FRANKLIN FACADE

NEWBURY FACADE

**A201**

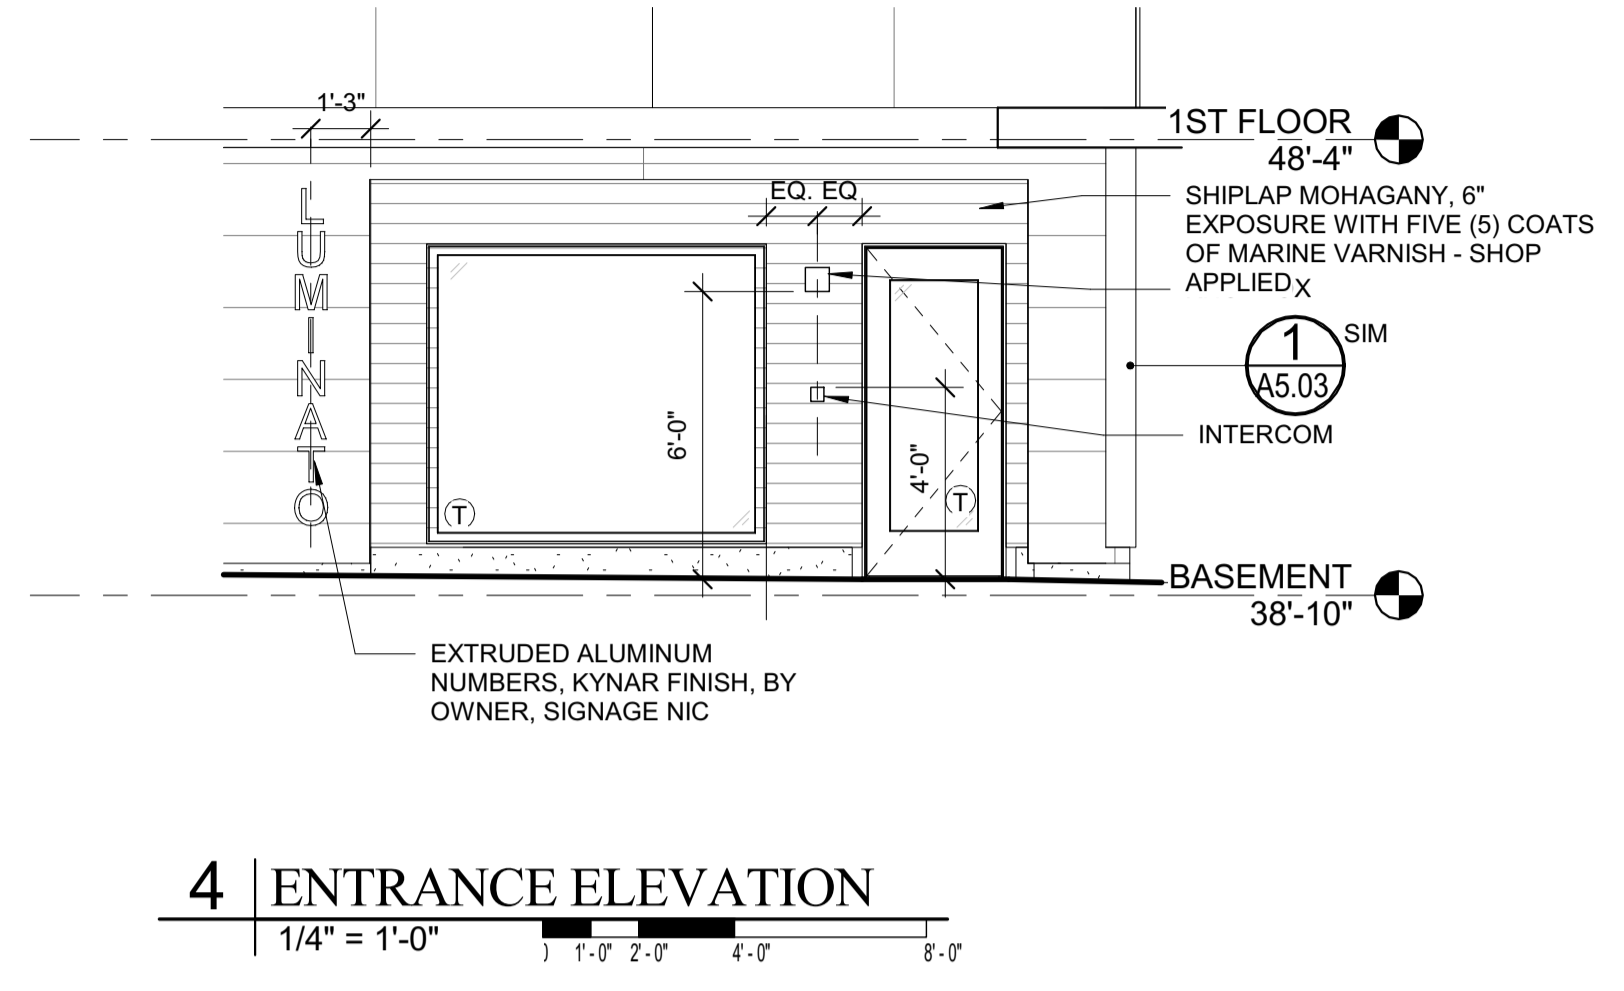
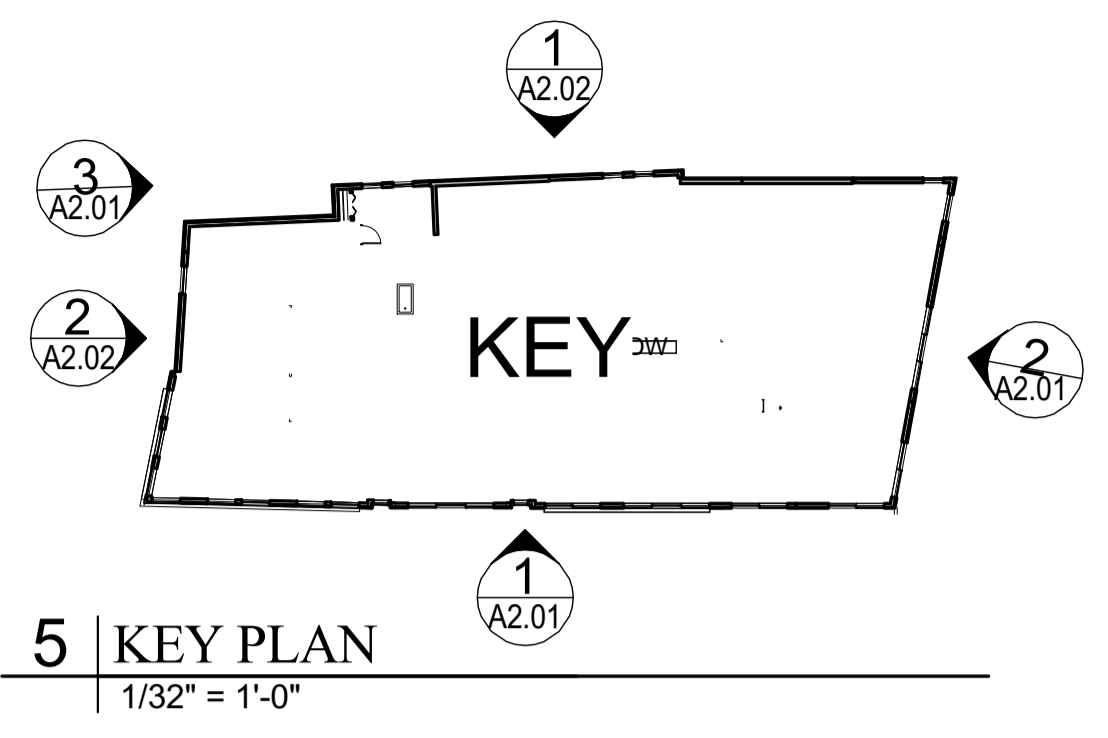
- Lighting + landscaping could activate Franklin facade
- In general, carry materiality of upper floors down to garage level
 - cladding material brought lower
 - two indentations brought down to ground
 - windows added to top garage level
- Base material more similar to rest of architectural palette in color

Emphasize corner w/ more height

Bring material down slightly
